Springwell Solar Farm

Written Summary of Oral Submissions
at Issue Specific Hearings 2, 3 and 4

EN010149/APP/8.22
Revision 1
Deadline 3
August 2025
Springwell Energyfarm Ltd

TITLE:  
FIGURE 3.11B  
VEGETATION REMOVAL PARAMETERS  
SPRINGWELL EAST

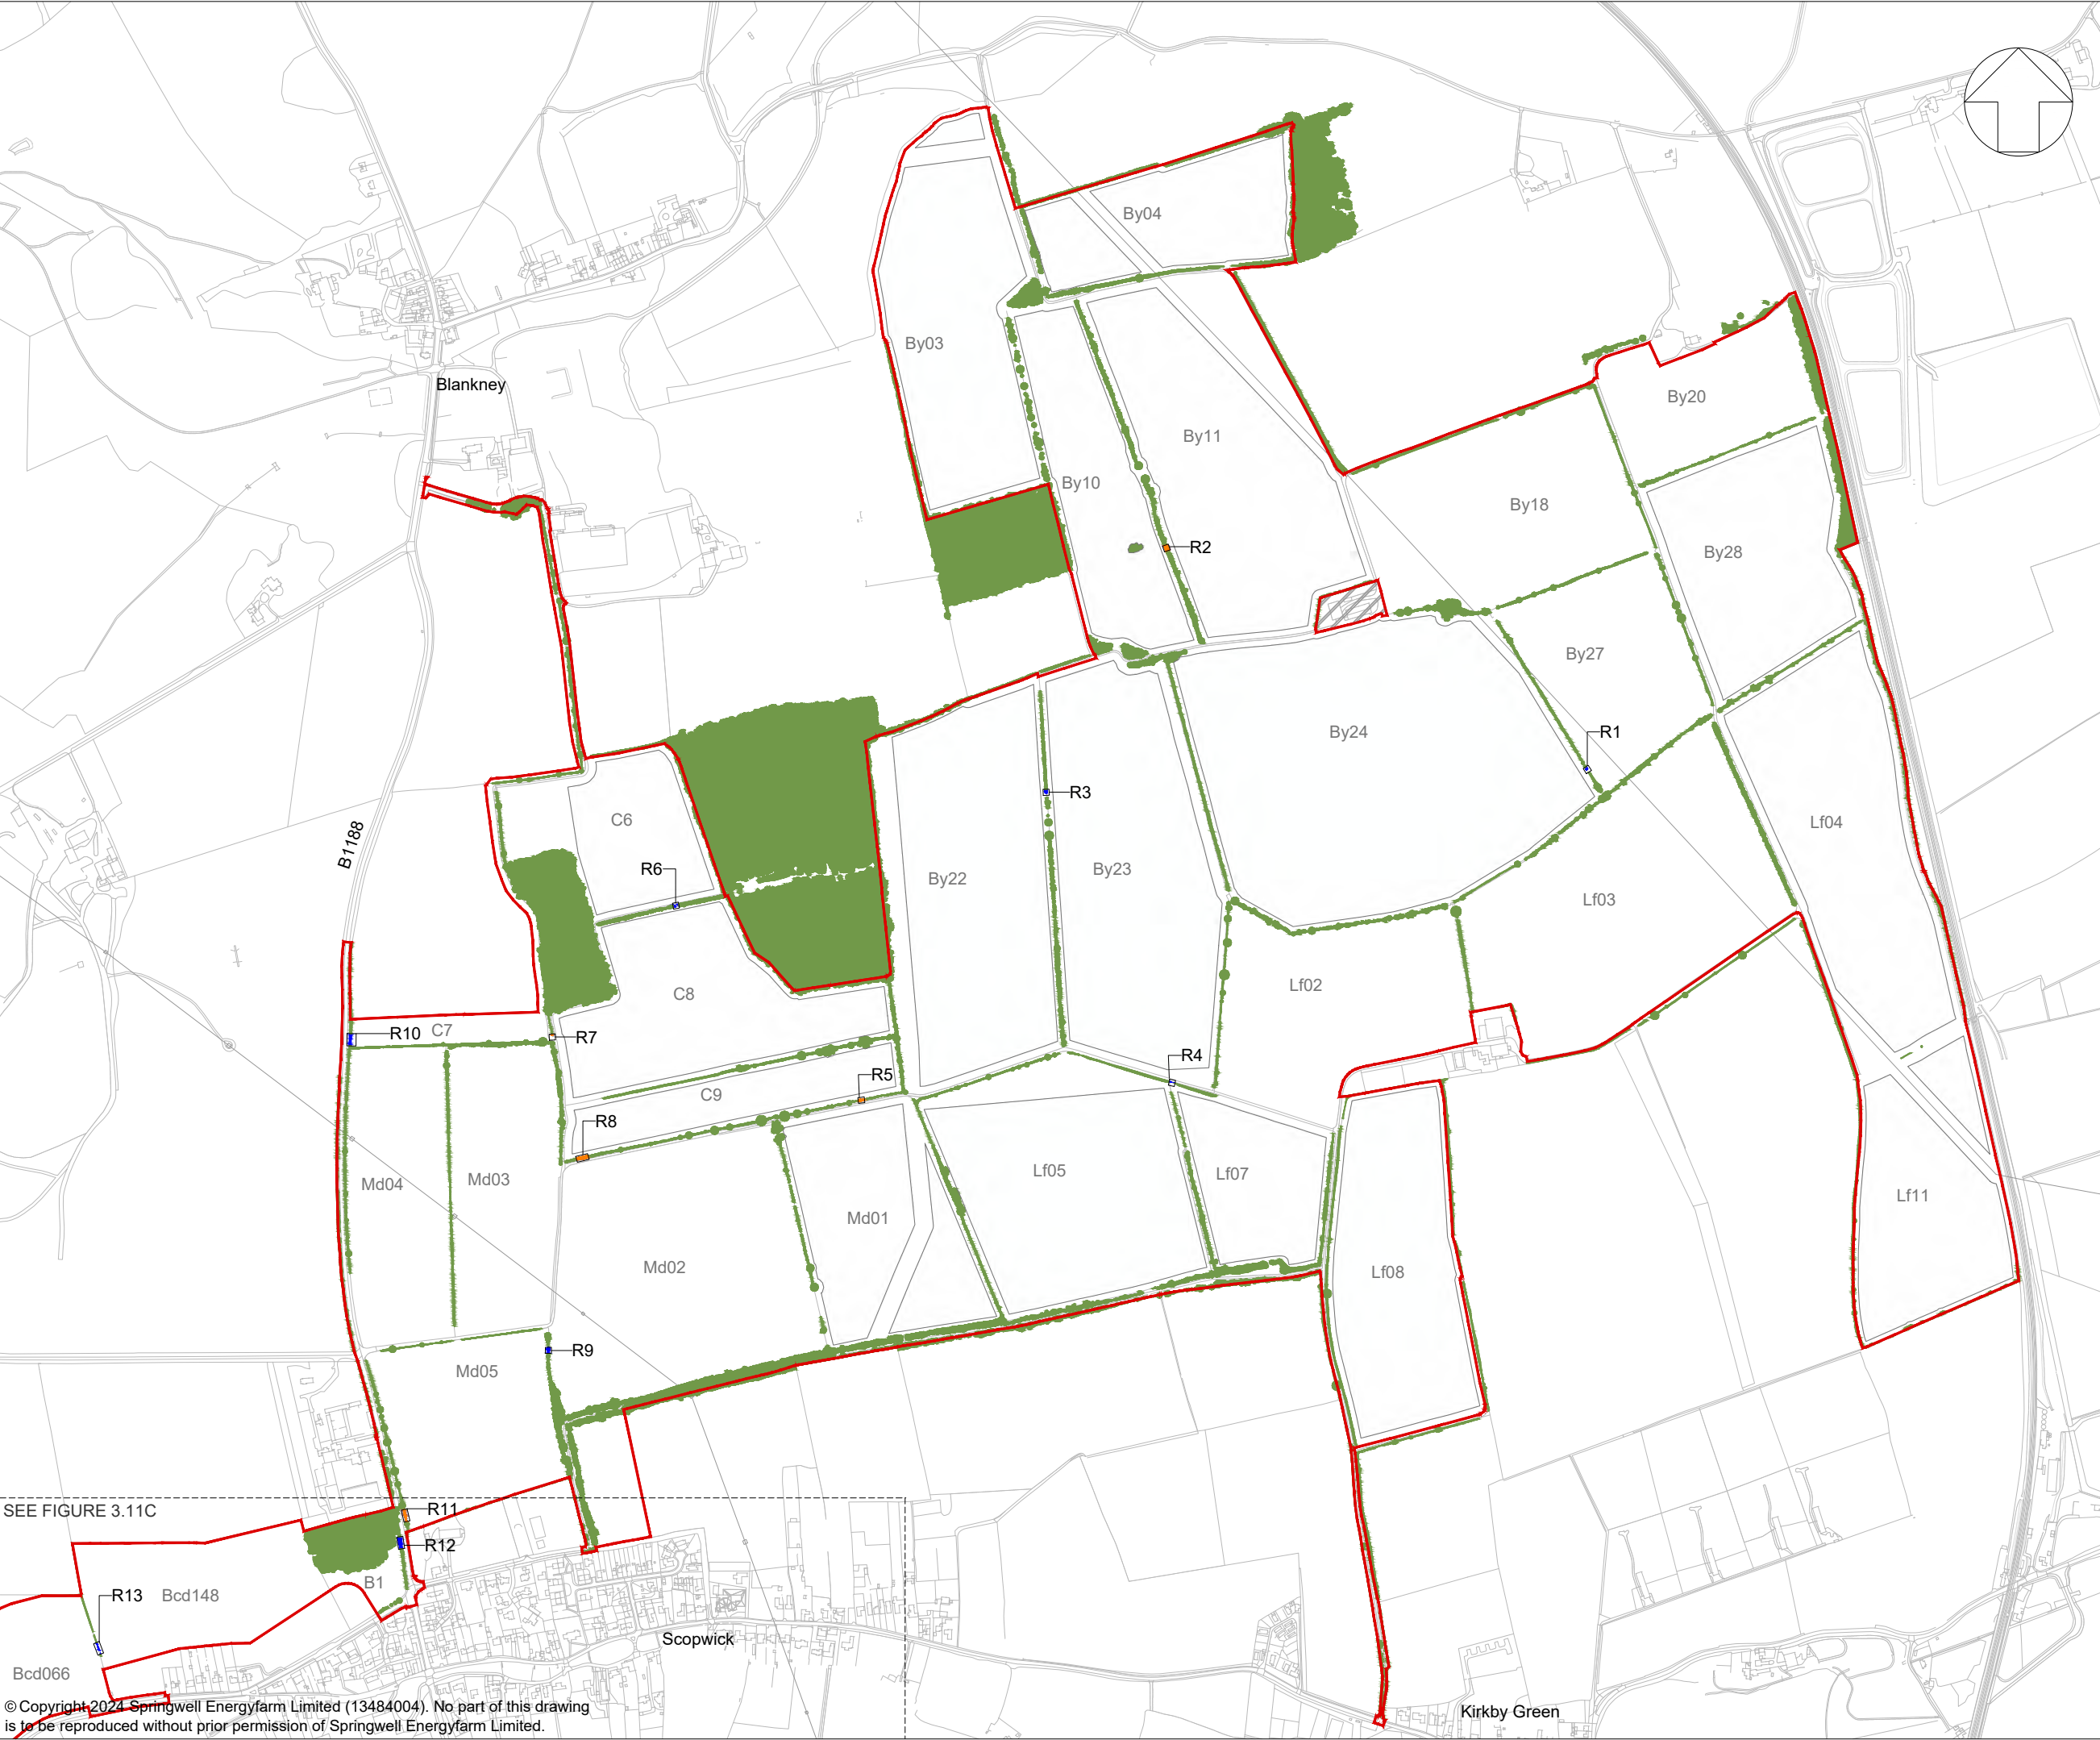
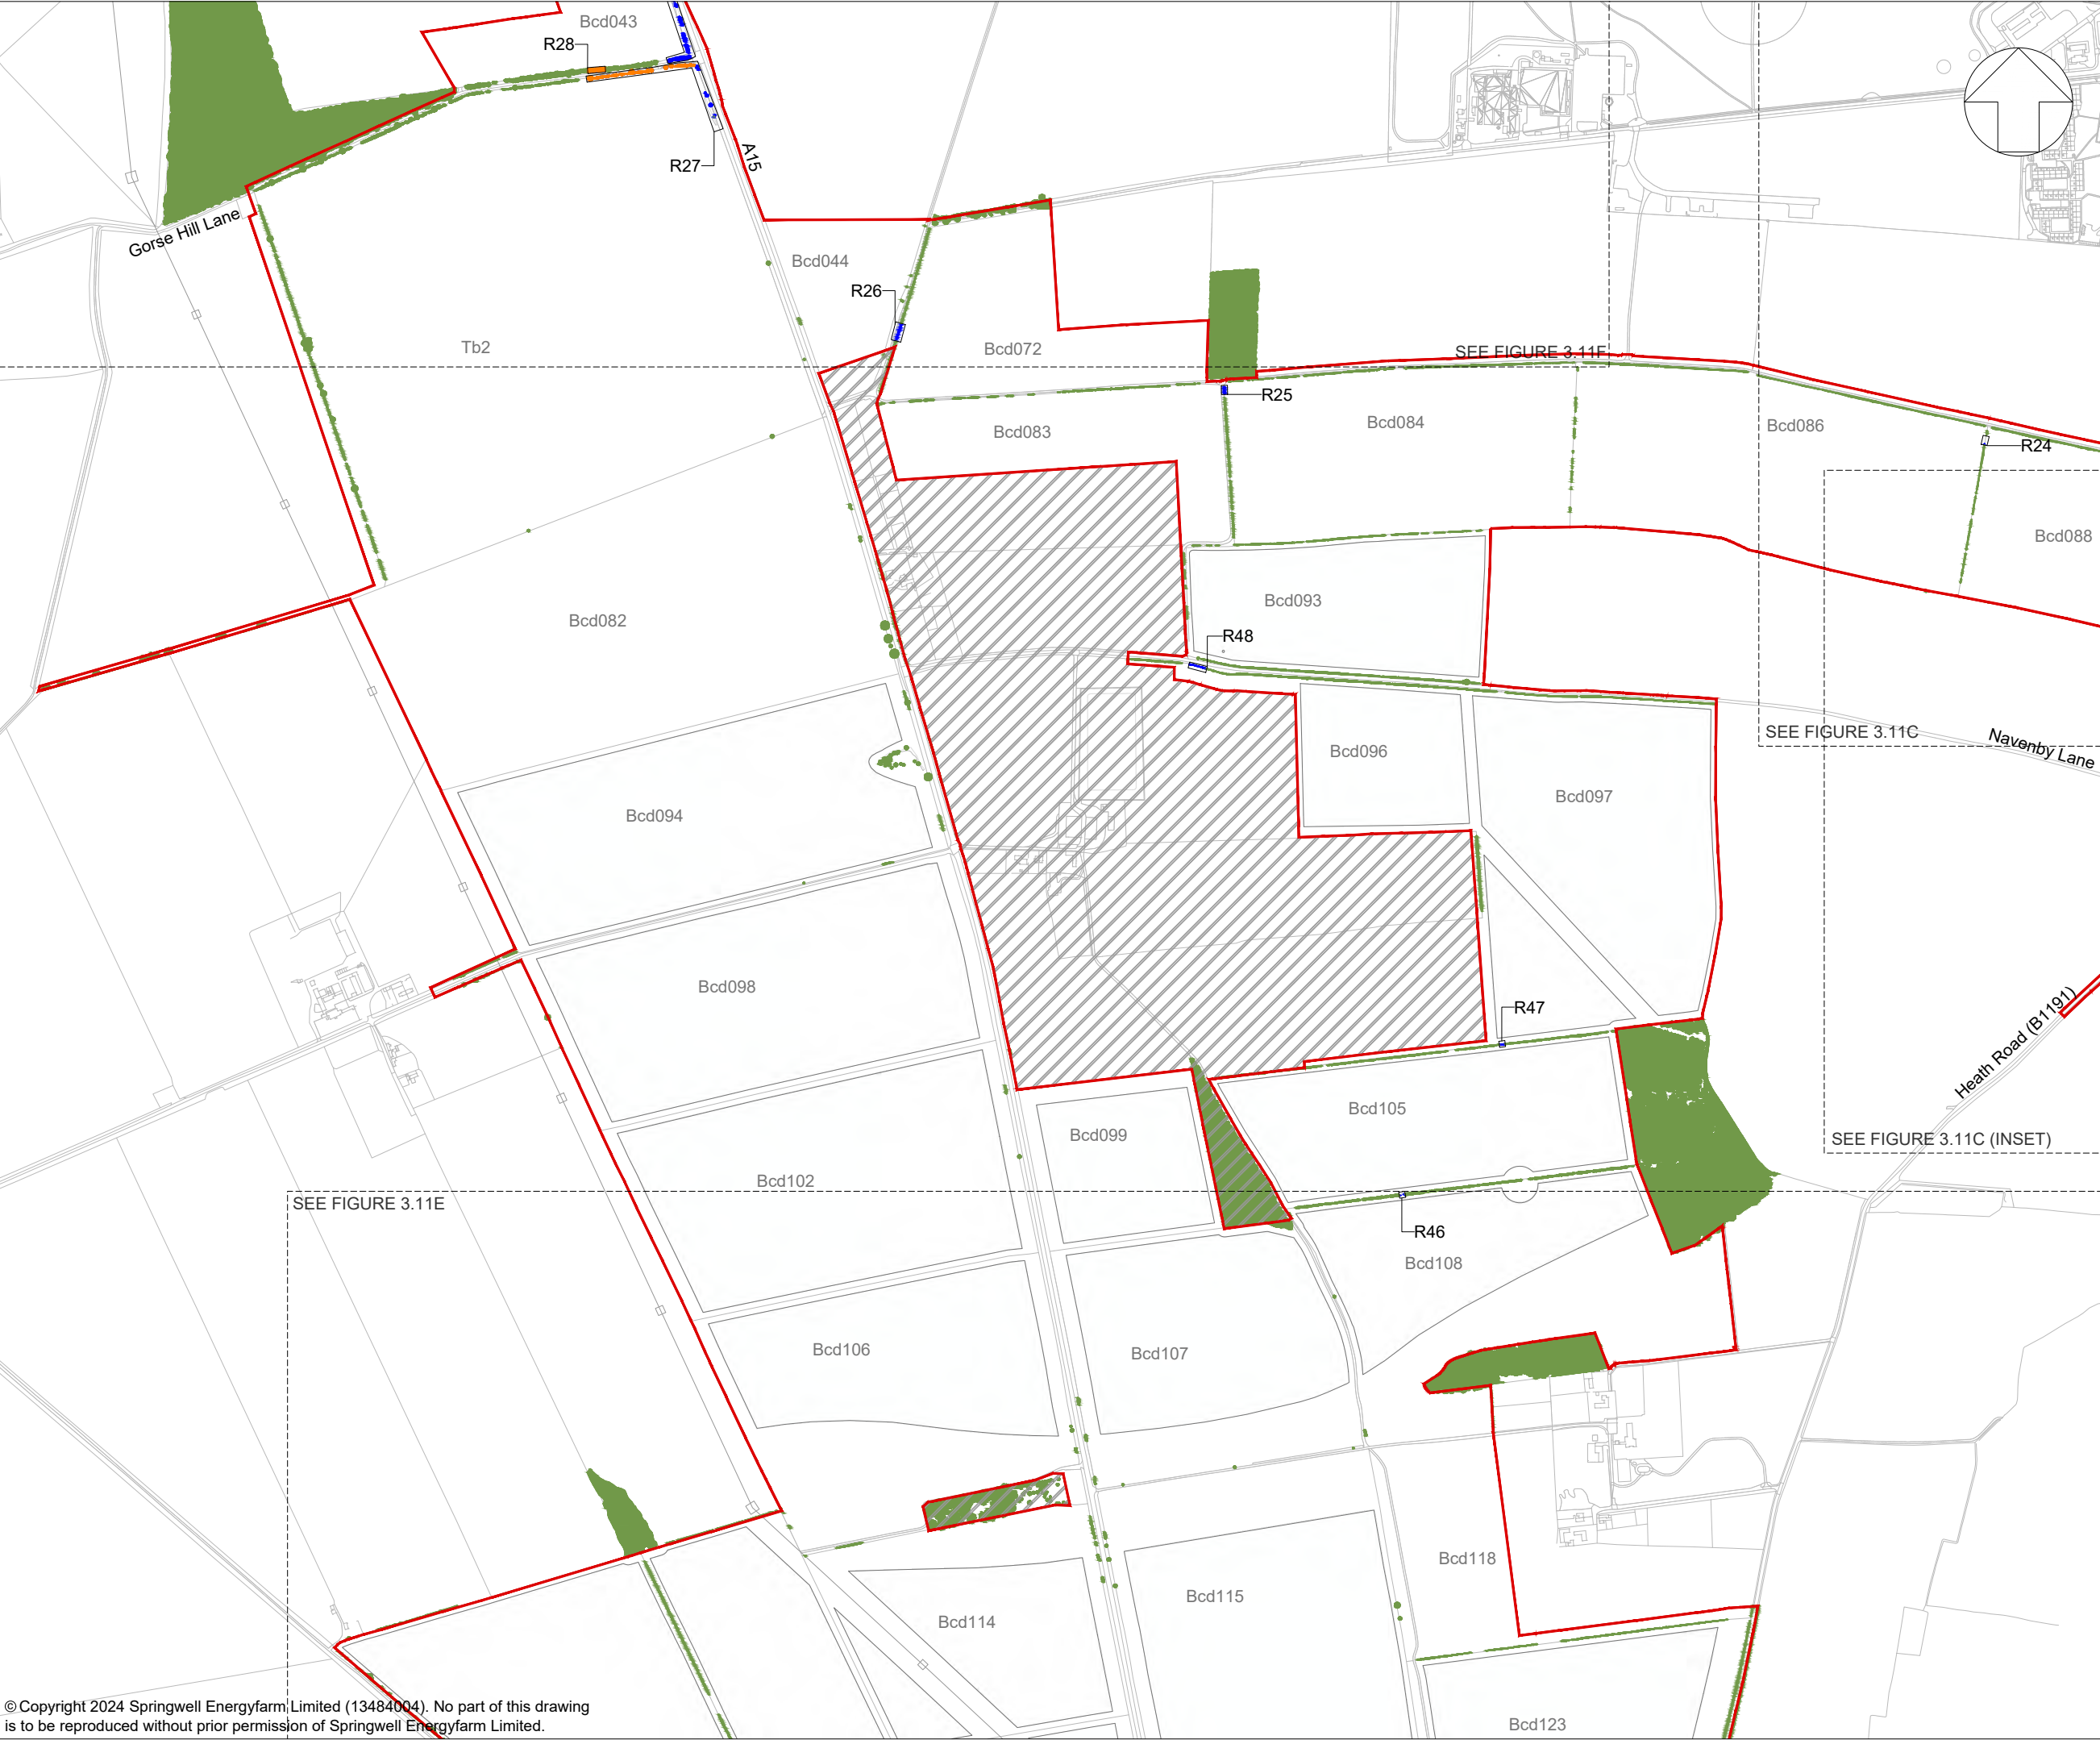
#	Agenda item	Written summary of Applicant's oral submissions at ISH 2
	3.3 The Applicant will be asked questions relating to the vegetation removal parameters (Figures 3.11A to 3.11F) [EN010149/APP/6.2.2] [REP1-027] and how landscape and visual impacts will be accounted for in finalising the location of vegetation removal.	<p>The ExA asked the Applicant if the vegetation removal parameters that are included in Schedule 13 of the Draft DCO [EN010149/APP/3.1.2] [REP1-006] are outline parameters that will inform detailed parameters. Mr Griffiths explained that the Applicant has applied a reasonable worst case approach in accordance with the Rochdale Envelope including the potential removal for these works.</p> <p>Mr Van der Nelson explained that the vegetation removal locations have been guided by the Project Principles and have included consideration of LVIA impacts as part of the pre-application design process. The vegetation removal parameters presented in the Outline Landscape and Ecological Management Plan (oLEMP) [EN10149/APP/7.9.2] [REP1-064] takes account of highways construction works, internal access tracks, cable routes and the grid connection corridor. He continued and explained that should the DCO be granted consent, detailed LEMP(s) will be produced for the Proposed Development in accordance with the DCO Requirement in Schedule 2 of the Draft DCO [EN010149/APP/3.1.2]. He added that the LEMP(s), as it could be one or more LEMPs, would require approval by the relevant planning authority prior to commencement of construction and would be required to be substantially in accordance with the framework set out in the oLEMP [EN10149/APP/7.9.2], including the Vegetation Removal Parameters presented in Appendix 2. Mr Van der Nelson explained that the Applicant has designed for a reasonable worst case and the design process means effects should get better. He continued that where future design choices need to be made, these will be guided by the oLEMP [EN10149/APP/7.9.2] [REP1-064], particularly the management objectives in section 4, such as the retention of existing vegetation wherever reasonably practicable (MO1), consideration of local landscape character (MO2) and protecting the amenity of PROW (MO9). The Design Commitments [EN010149/APP/7.4] [APP-0138] provide further controls regarding vegetation removal, for example, 'Internal access tracks and cable routes will use existing access tracks, crossings and/or gaps in the hedgerows where practicable' (D1) that the Applicant will need to demonstrate compliance with when the detailed design is submitted to the relevant planning authority under Requirement 5 of the Draft DCO [EN010149/APP/3.1.2] [REP1-006].</p>

#	Agenda item	Written summary of Applicant's oral submissions at ISH 2
		<p>The ExA asked the Applicant if the vegetation removal areas are to be in different areas to the vegetation removal plan or if will it be within refined areas of the parameter areas, and how will LVIA impacts be taken into account in finalising the vegetation removal. Mr Griffiths on behalf of the Applicant explained that there will be refinement in the vegetation removal plan as the Applicant has made a reasonable worst case assessment. As is established in case law, there is no obligation on a developer to assess every permutation that could arise on any scheme. In any event, Schedule 16 of the Draft DCO [EN010149/APP/3.1.2] [REP1-006] provides a safeguard because when approving the LEMP the Applicant will need to provide the relevant planning authority with a statement setting out if there are any new environmental effects, which the relevant planning authority will consider and confirm if they agree. If there is a difference that the Applicant could not predict e.g. because the baseline has changed, the Applicant would include that in its statement and the relevant planning authority can assess the difference through that mechanism and determine whether to approve the discharge of the requirement.</p> <p><i>Visual Impact and Design</i></p> <p>3.4 The Applicant will be asked about the design process that is secured in the draft Development Consent Order and control documents.</p> <p>The ExA asked the Applicant if there has been a design process to date that shows that the colour commitments in design commitment D17 are appropriate, such as a landscape colour study or a study of local buildings that have informed the issues. Mr Van der Nelson stated that the Applicant will come back in writing on this point, but in accordance with the requirement 5 in the Draft DCO [EN010149/APP/3.1.2] [REP1-006] the Applicant must have detailed design approved by the relevant planning authority.</p> <p>The ExA noted that Requirement 5 lists in accordance with the Design Commitments [EN010149/APP/7.4] [APP-0138], but wanted further information on how the colours in the Design Commitments [EN010149/APP/7.4] [APP-0138] had been identified. Mr Griffiths explained design commitment D17 states that the colours must be sensitive to the local environment, so when the Applicant submits the detailed design to the relevant planning authority that is the security mechanism. He also noted that the Applicant considers</p>

#	Agenda item	Written summary of Applicant's oral submissions at ISH 2
		<p>these colours appropriate and that consultation with the relevant planning authorities has been carried out, including on the project's design-led approach as set out in the oLEMP [EN010149/APP/7.3.2] [REP1-056]. He added that the colours are also not restricted to grey or dark green but could include other finishes to suit local building styles. Mr Van der Nelson explained the LVIA has fed into this design process too. The ExA clarified that the principle of the query about colour choice in the Design Commitments [EN010149/APP/7.4] [APP-0138] applies to all of the larger components of the Proposed Development, including Work Numbers 2, 3 and 4.</p> <p>Mr Samuel Sheikh, Counsel for North Kesteven District Council (NKDC) raised a concern about the flexibility at the discharge of requirements stage, as the Design Commitments [EN010149/APP/7.4] [APP-0138] specifies specific colours. NKDC will put their views in writing. The ExA asked the Applicant if any consultation had been held on these colours. Mr Griffiths confirmed there had been consultation on the Project Principles (which are the design principles considered as part of the DAD). The Applicant will respond in writing if it considers it appropriate to provide any more flexibility to amend the design principles.</p> <p>Post hearing note: The Applicant has provided a written response to address the points raised in this section in Action Point 2 and Action Point 3 of the Response to Action Points, which is appended to this document.</p> <p>3.5 North Kesteven District Council will be asked to expand on its concerns relating to the visual impact of highways components.</p> <p>Mr Oliver Brown for NKDC confirmed that the Applicant has clarified what was included in the vegetation works. There has been a meeting with the Applicant and they have clarified how the process will work – including the vegetation removal plans within the oLEMP [EN010149/APP/7.9.2] [REP1-064] and how it is secured within the Draft DCO [EN010149/APP/3.1.2] [REP1-006]. He added that NKDC is happy in terms of the information that has been presented in the vegetation removal plans and the information presented in the LVIA.</p>
